# City of Albuquerque Stormwater Construction Site Inspection Report

ESC File No.	H10E033	Project Name:	2200 Vista Oriente NW		
NPDES Id. No.	NMR10036M	Location:	2200 Vista Oriente NW		
8/19/2021	Owner			Contractor	
Operator	Tuan Huynh				
Contact name & title	Tuan Huynh				
e-mail	<a href="mailto:tuanvhn@yahoo.com">tuanvhn@yahoo.com</a>				
Contact Phone #	505-269-1418				
COA Inspector	Doug Hughes		Start/End Time:	11am	
Construction Phase:	Pre-construction				
Type of Inspection:	Regular	Storm Event	Past Storm Event >0.25"	311/Complaint	Follow Up
Weather at time of inspection?		clear		Temperature: ~	89
Estimated date of last storm 0.25" or greater			7/31/2021

TEMPORARY EROSION AND SEDIMENT CONTROL PLAN

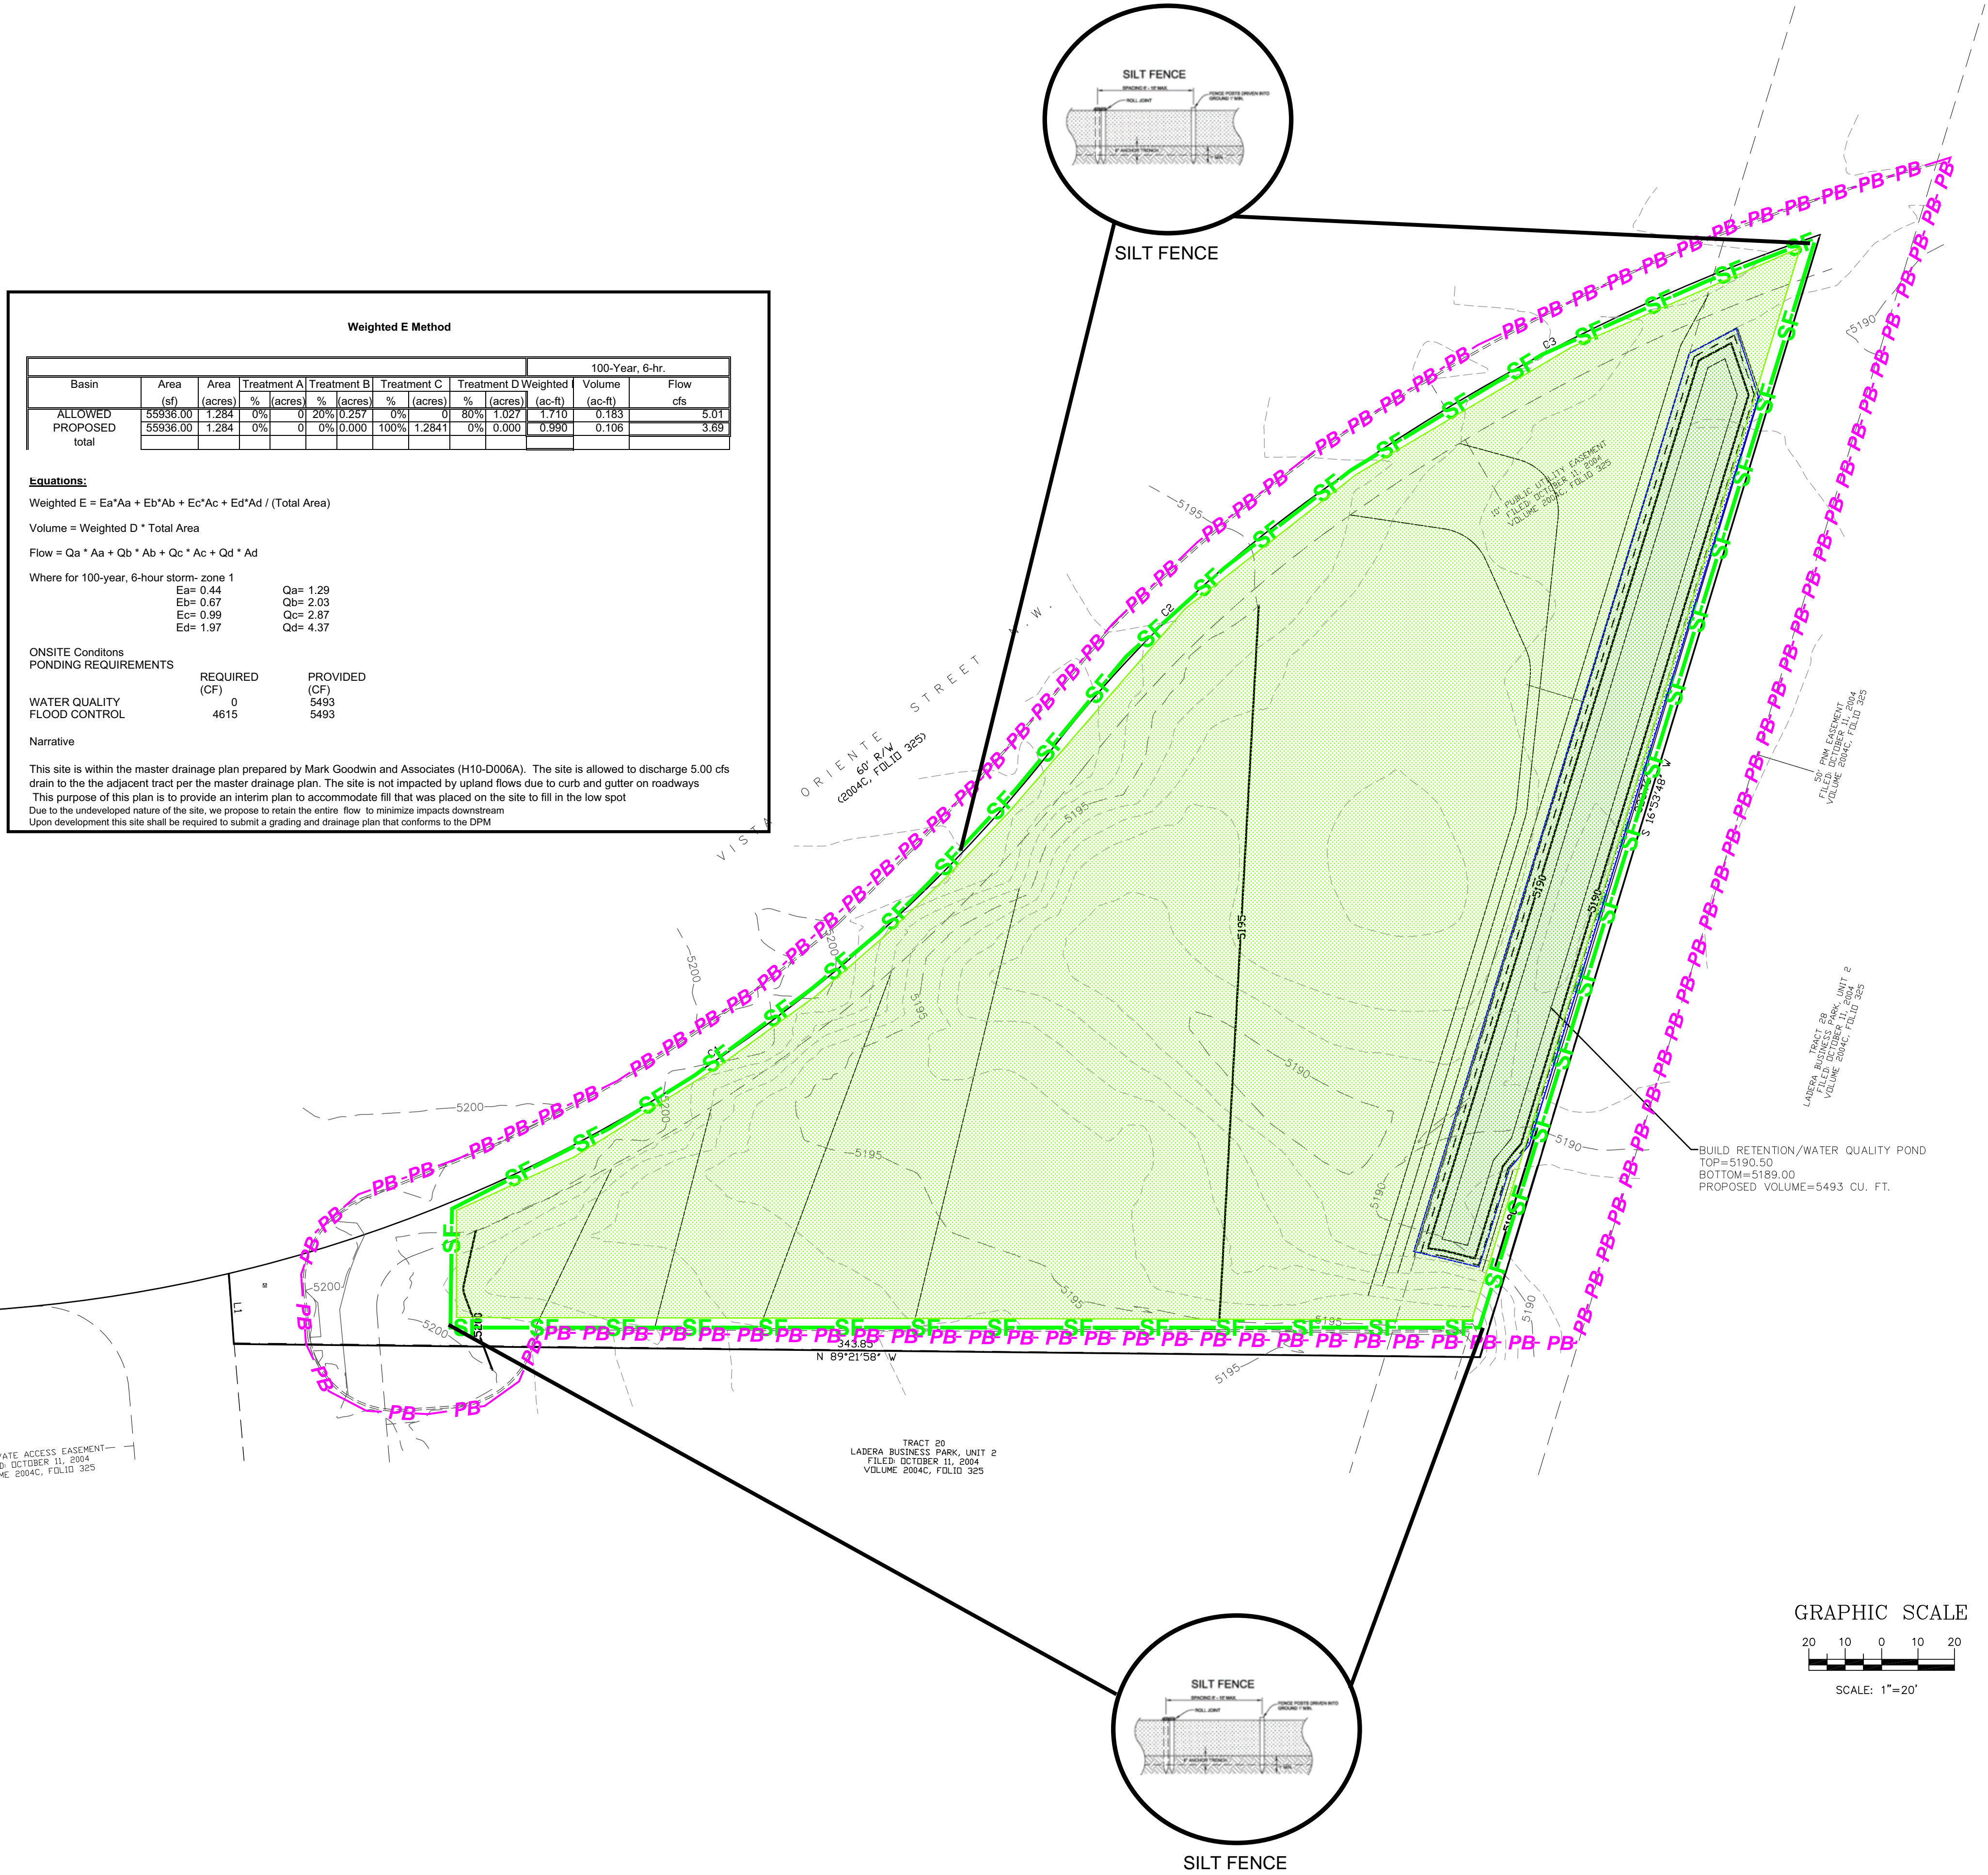
Item Number	Deficiency/ Corrective Action				
1	Weeds should not be any taller or wider than 4". Trim or pull weeds.				
2	The SWPPP must be up-to-date and available onsite.				
3	The Silt Fence needs minor repairs.				
4	NPDES Posting was missing.				
5	Stabilize the site per CGP 2.2.14

Notes:	Silt Fence needs minor repair, No sign of Stabilization per CGP 2.2.14,
	The site is inactive and covered with tumble weeds that exceed the maximum 4" width and
	4" Height allowed by ordinance § 9-8-4 GROWTH OR ACCUMULATION OF WEEDS AND LITTER
